From: Guy Hird [REDACTED]
Sent: 03 December 2020 11:19
To: South Humber Bank <SouthHumberBank@planninginspectorate.gov.uk>
Subject: EN010107 South Humber Bank Energy Centre

EN010107 South Humber Bank Energy Centre
The Planning Act 2008 – Section 89 and The Infrastructure Planning (Examination Procedure) Rules 2010 – Rule 8
Application by EP Waste Management Limited for an Order Granting Development Consent for the South Humber Bank Energy Centre

Thank you for the opportunity to comment on the above proposed development. The site is within the North East Lindsey Drainage Board area.

Document Reference: 8.8 Key & Watercourses and Flow Direction Diagram

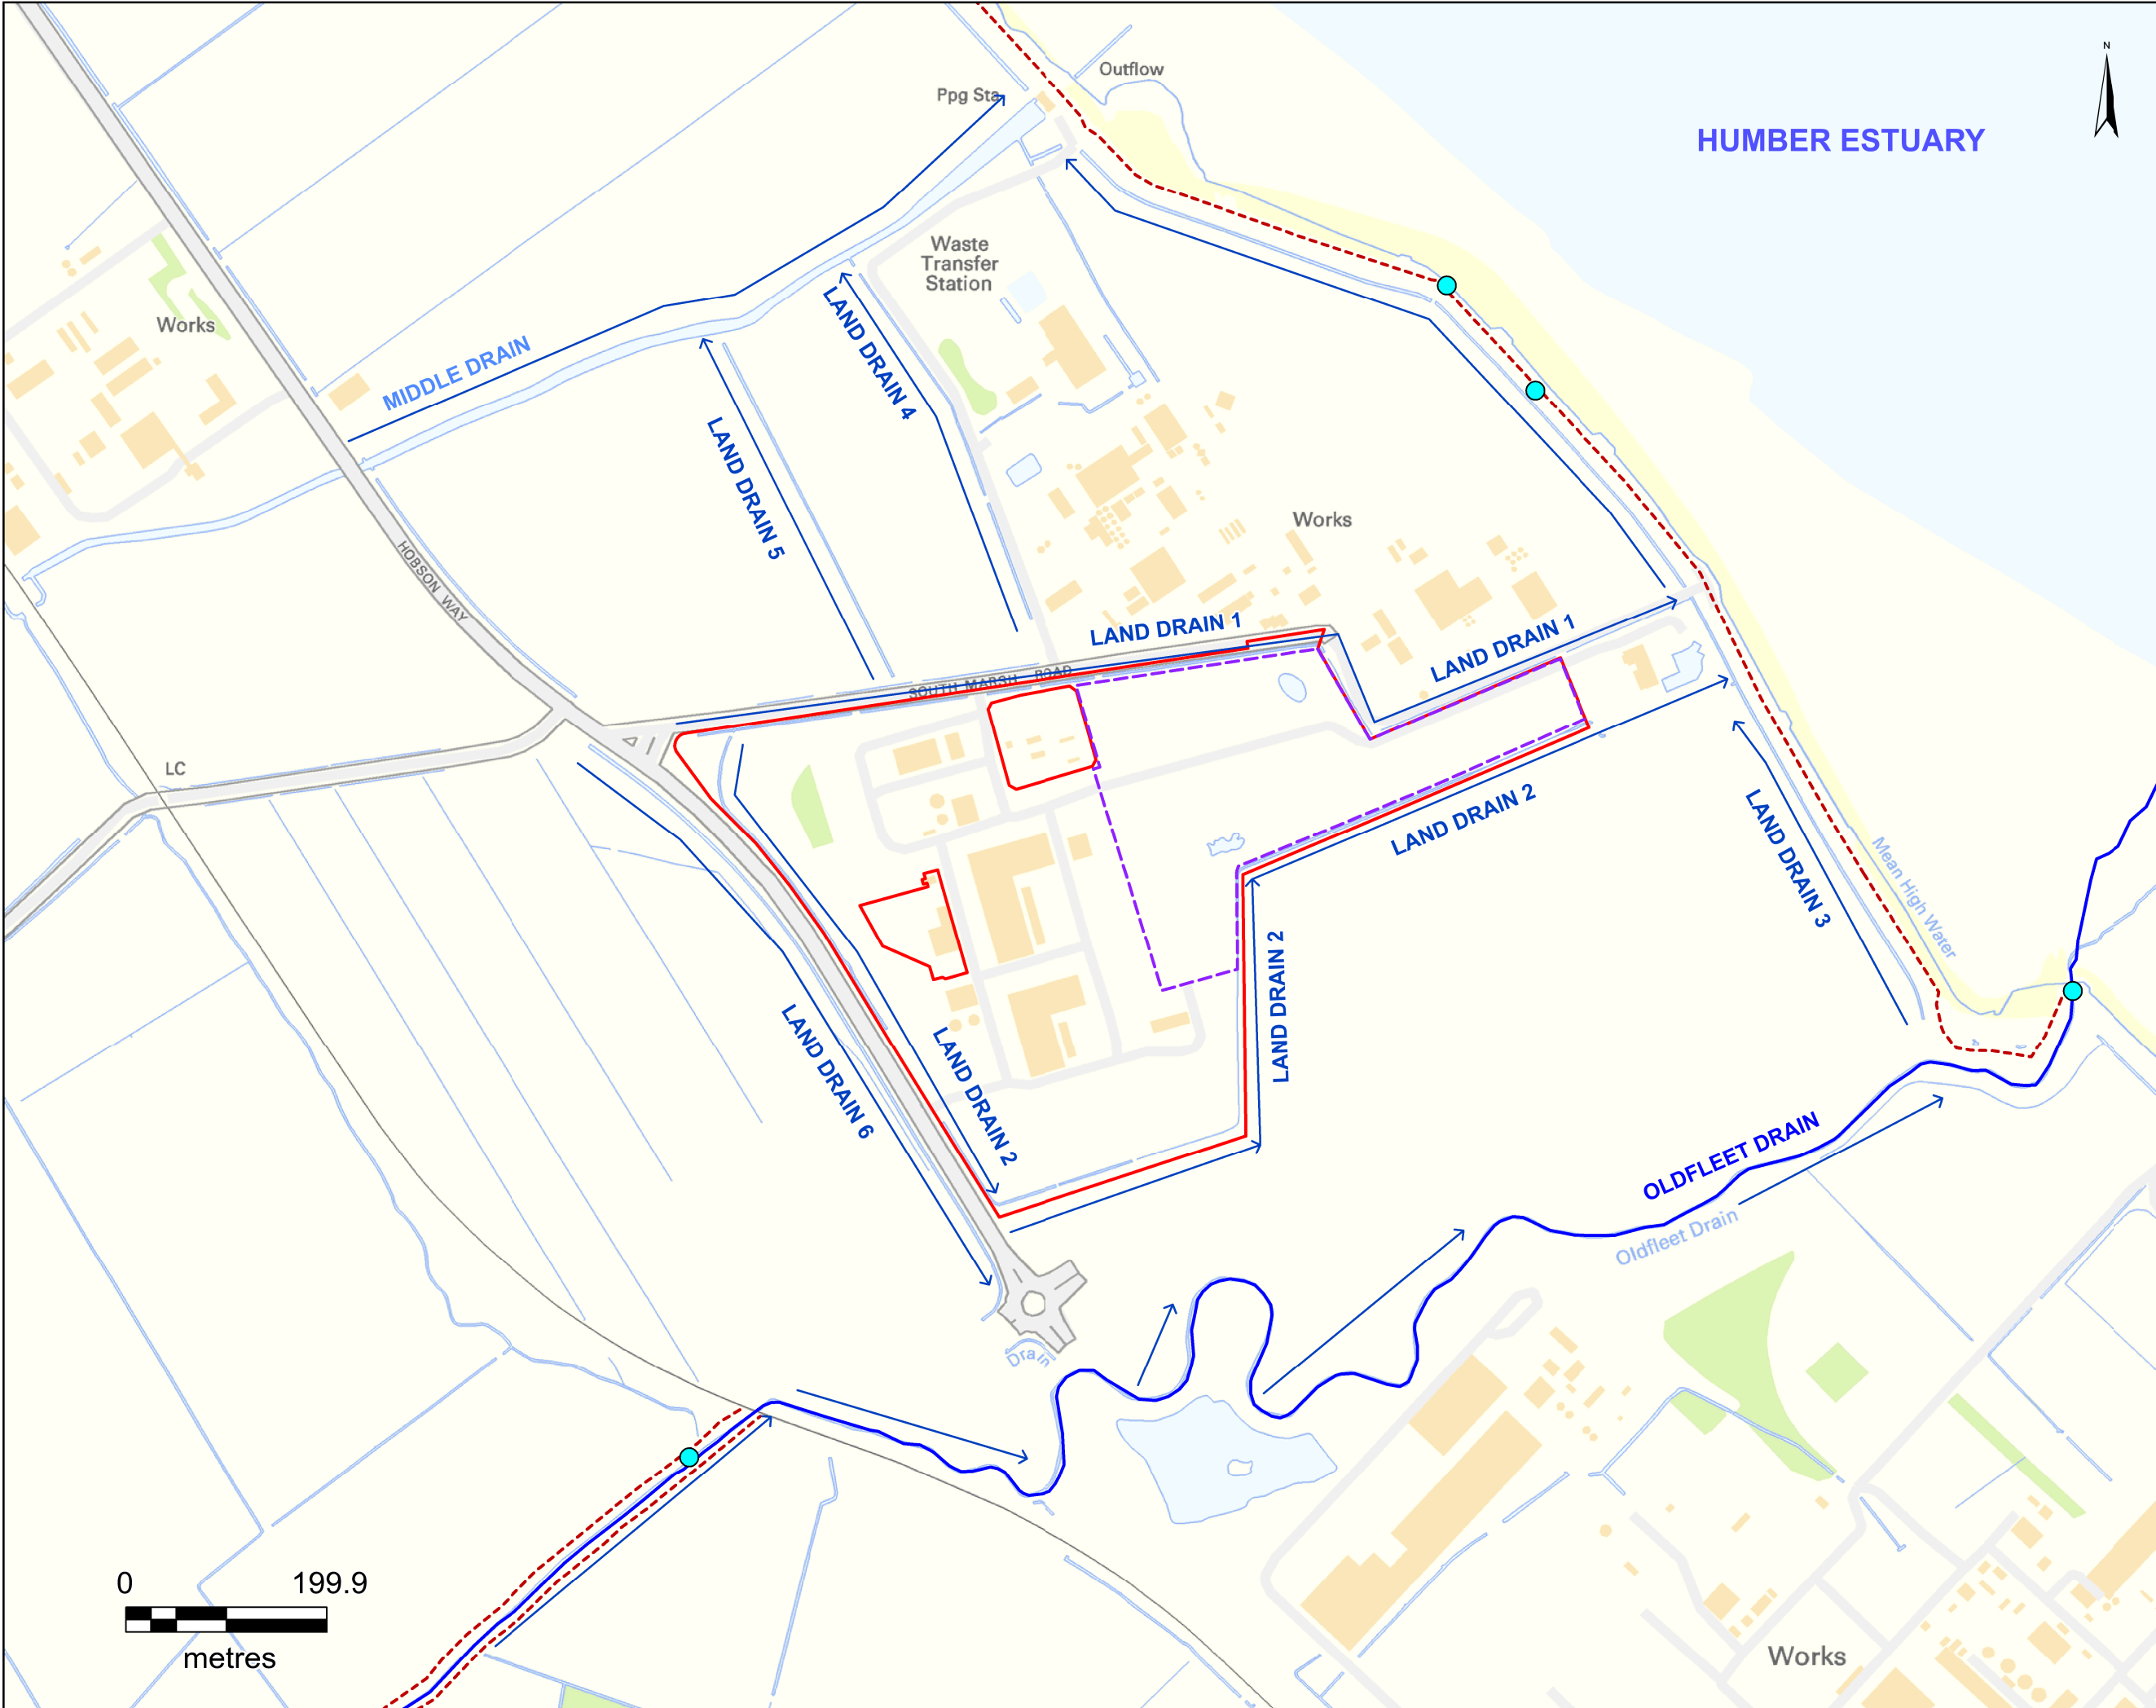
As a matter for correction on the 'Key Watercourses & Direction' drawing 'Land Drain 3' is shown as flowing towards 'Oldfleet Drain' this is incorrect all flows from the catchment flow to the gravity outfall/Middle Drain pumping station.
